DEVELOPMENT FACILITATION TEAM

PR-2022-007507

PA-2025-00168 – SKETCH

REQUEST: To create two lots from one lot and vacate easements and grant easements as shown on the plat

Plat of
Tracts A-1-A and A-1-B
LLD Subdivision
Elena Gallegos Grant, Projected
Sections 34 & 35, Township 11 North, Range 03 East, N.M.P.M.
Albuquerque, Bernalillo County, New Mexico
June 2024

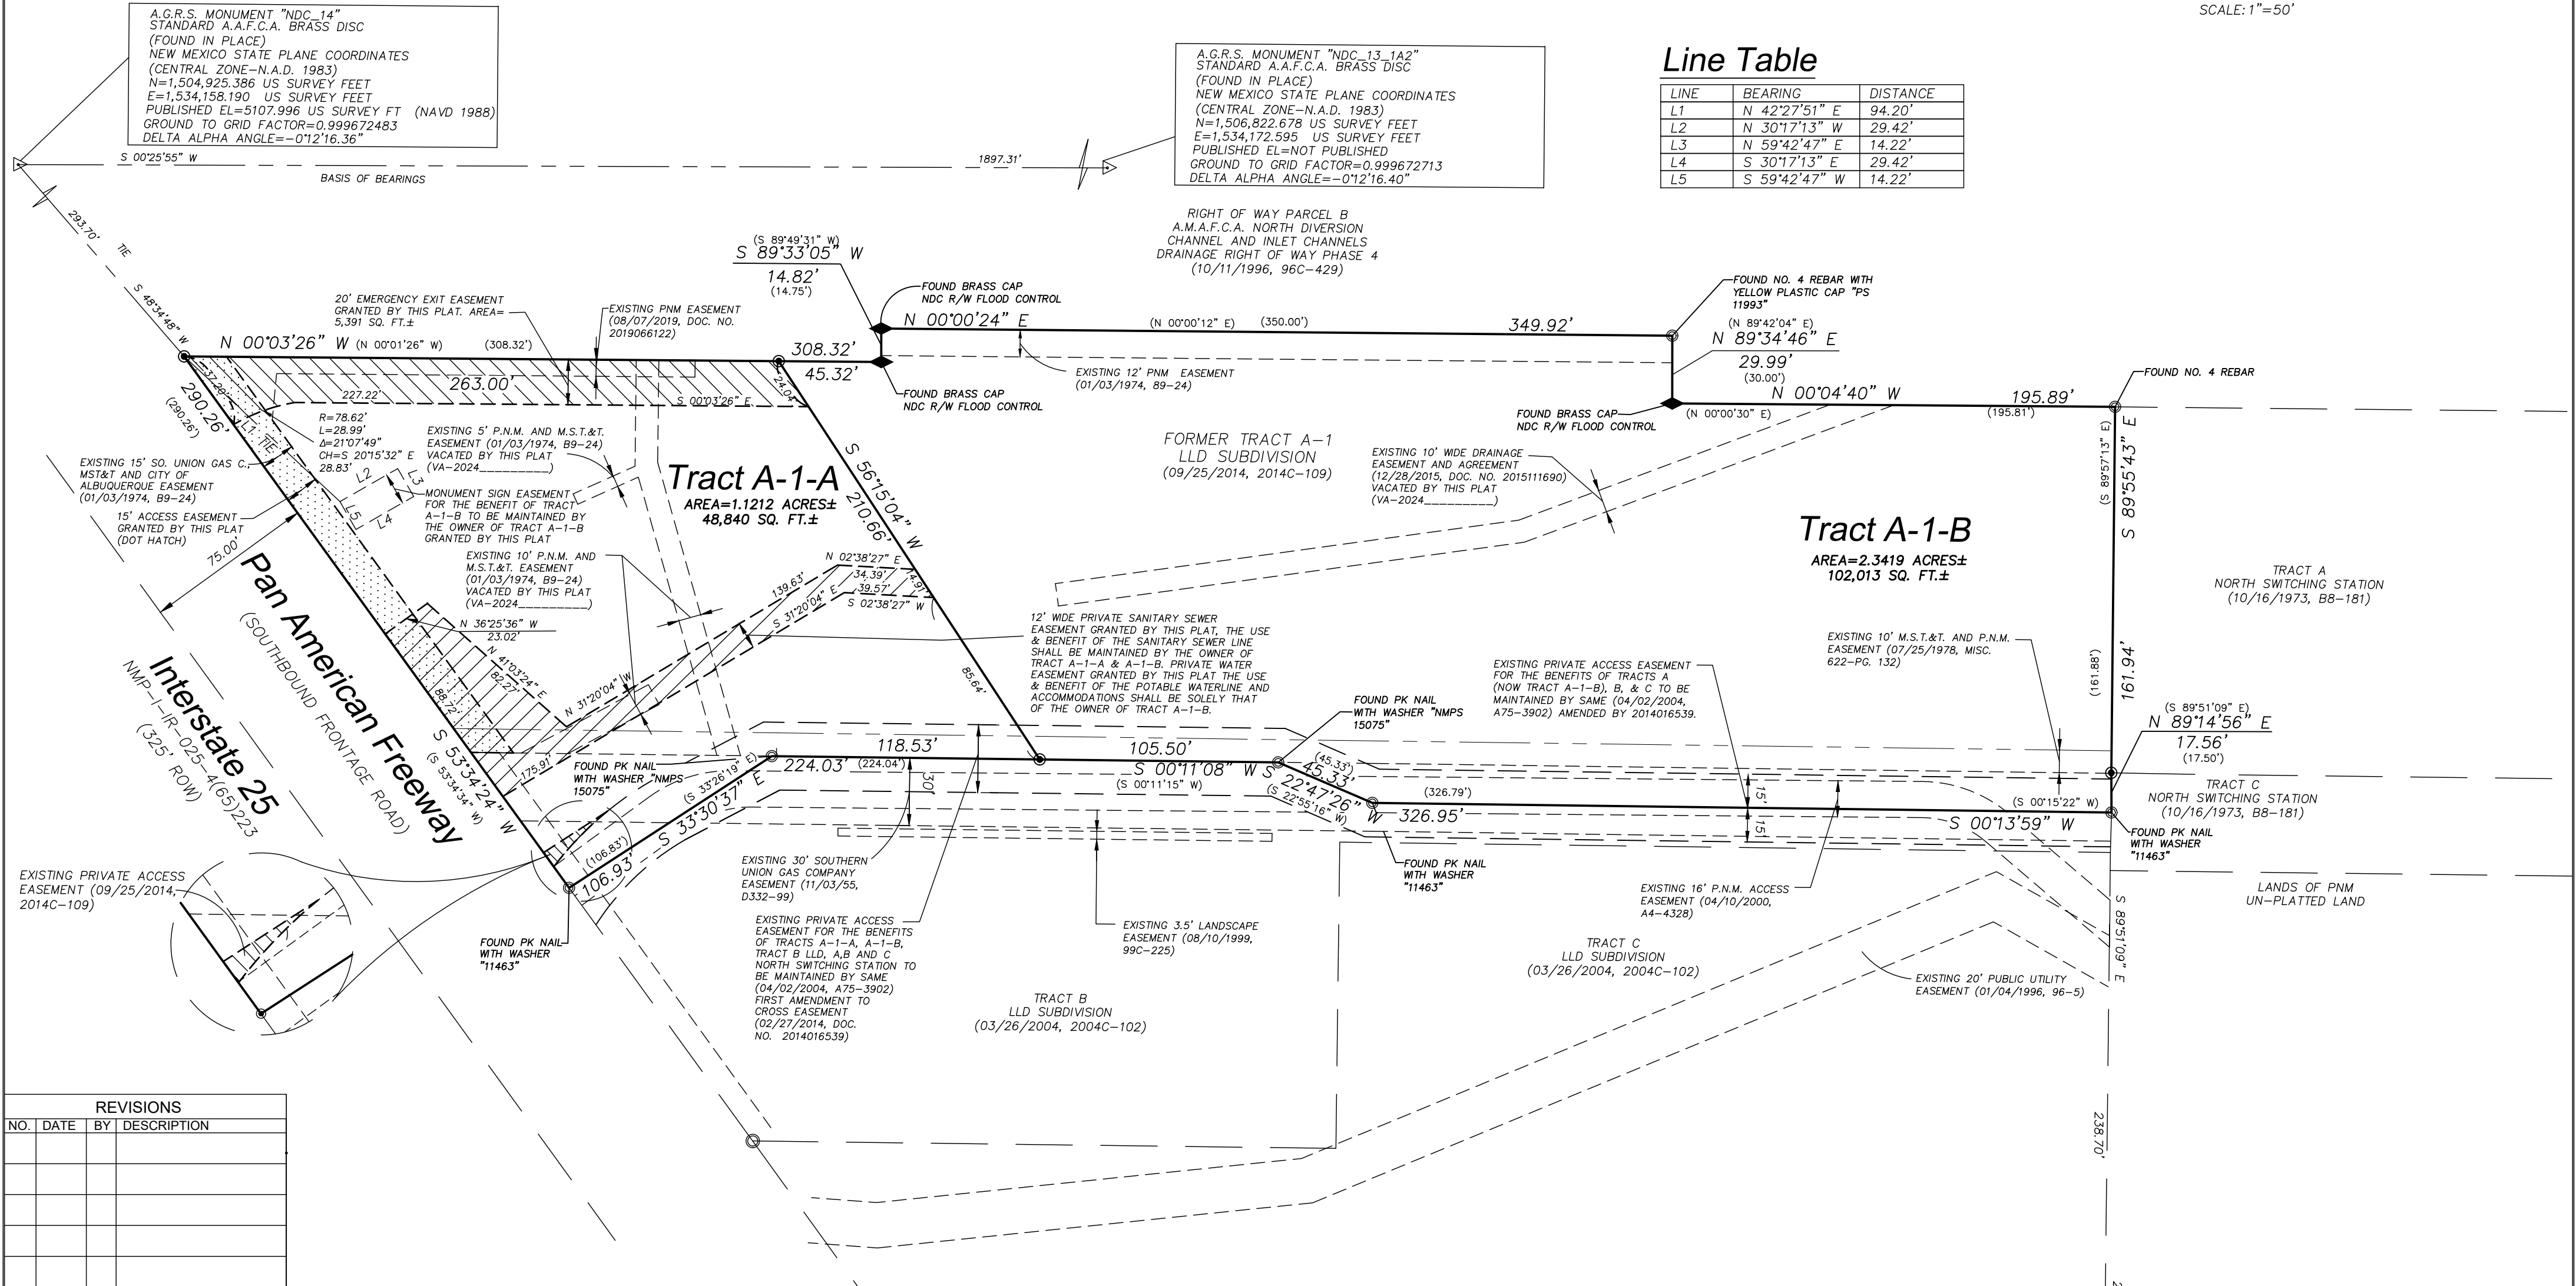
- Please clarify any development changes, i.e. demolition, expansion, new structures, or new uses.
- All standards within IDO section 5-4-C (Subdivision of Land Compliance) apply to all re-platting actions. Re-platting action cannot increase any existing nonconformity or create a new nonconformity
- Please provide update parking calculations for the subject property to ensure that the minimum will still be met for the underlying zoning requirements.
- The plat will need to be updated in some sections to reflect the current year. See picture below for reference.

EXISTING 10' WIDE DRAINAGE
EASEMENT AND AGREEMENT
(12/28/2015, DOC. NO. 2015111690)
VACATED BY THIS PLAT
(VA-2024_____)
